**CITY OF ALBUQUERQUE
PLANNING DEPARTMENT
December 6, 2006
DRB Comments**

PROJECT #1004496

APPLICATION # 06-01666

RE: Lots 1,1A,1B, & 1C, The Bluffs @ Encantado/fp

P.O. BOX 44414 RIO RANCHO, N.M. 87174  
Phone (505) 896-3050 Fax (505) 891-0244

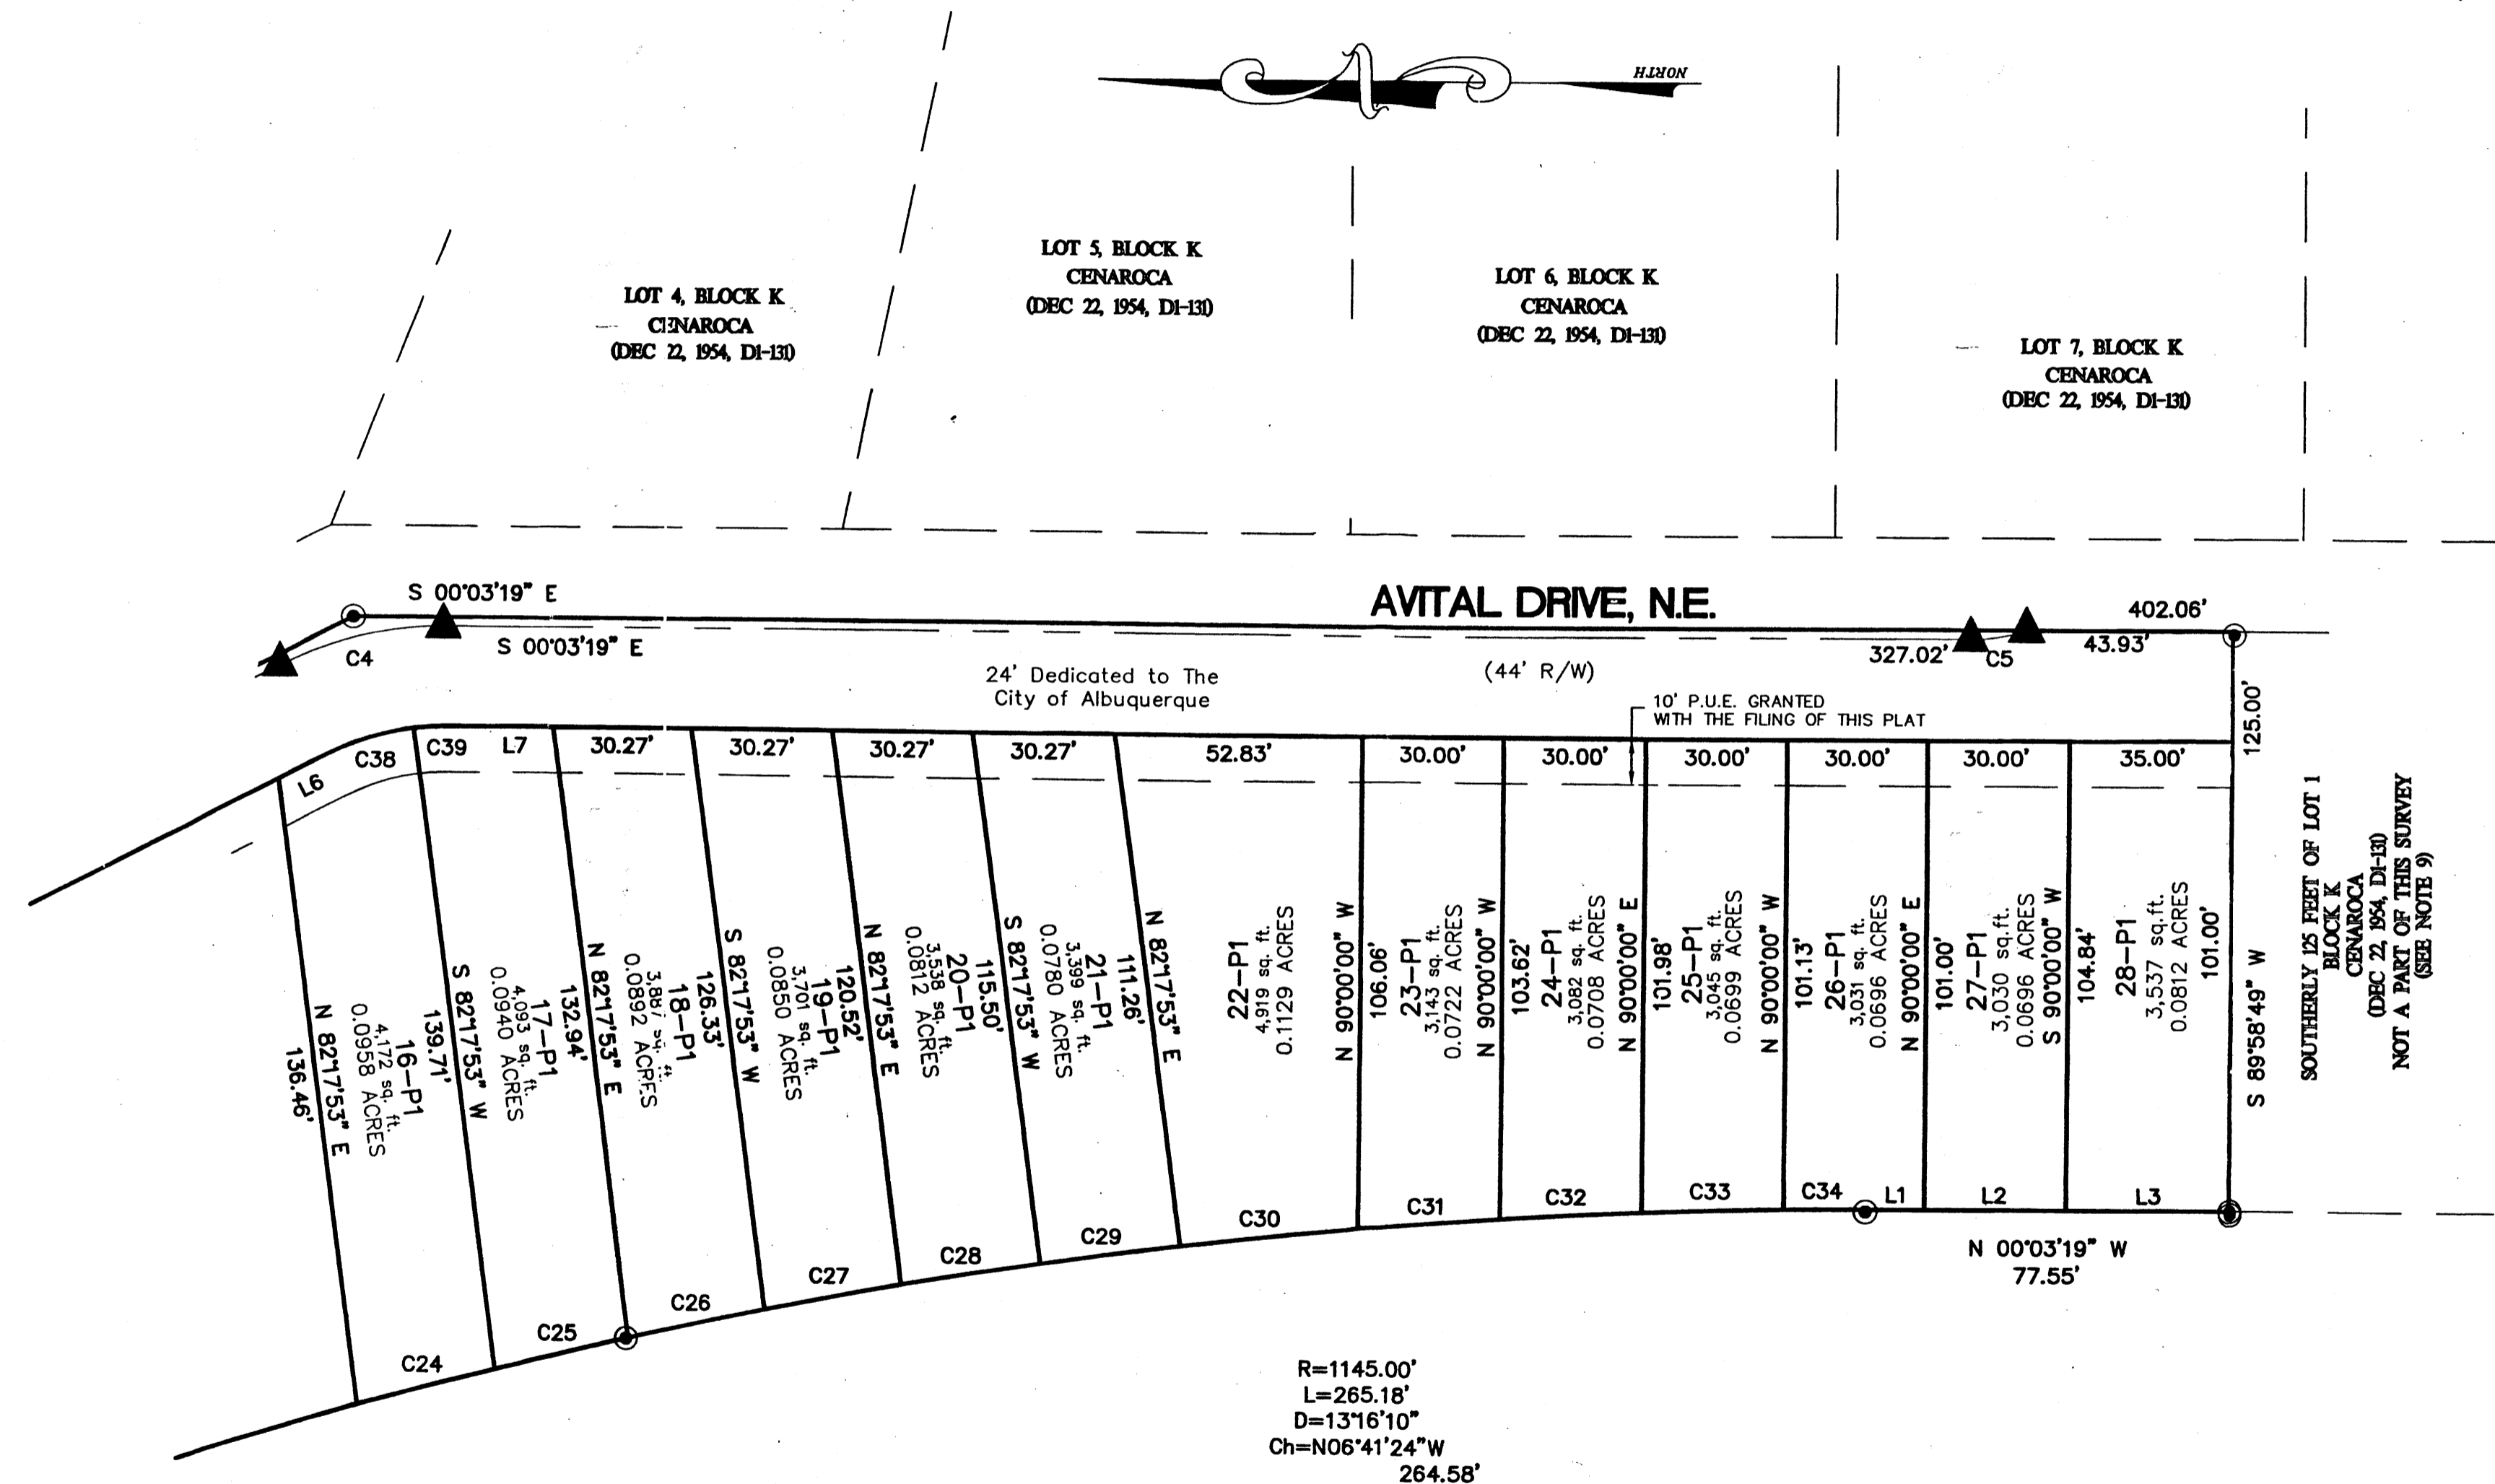
lots 2-PI & 3-PI must be 30'

There are two lots (2-P1 & 3-P1) that do not meet the minimum lot width of 30 feet.
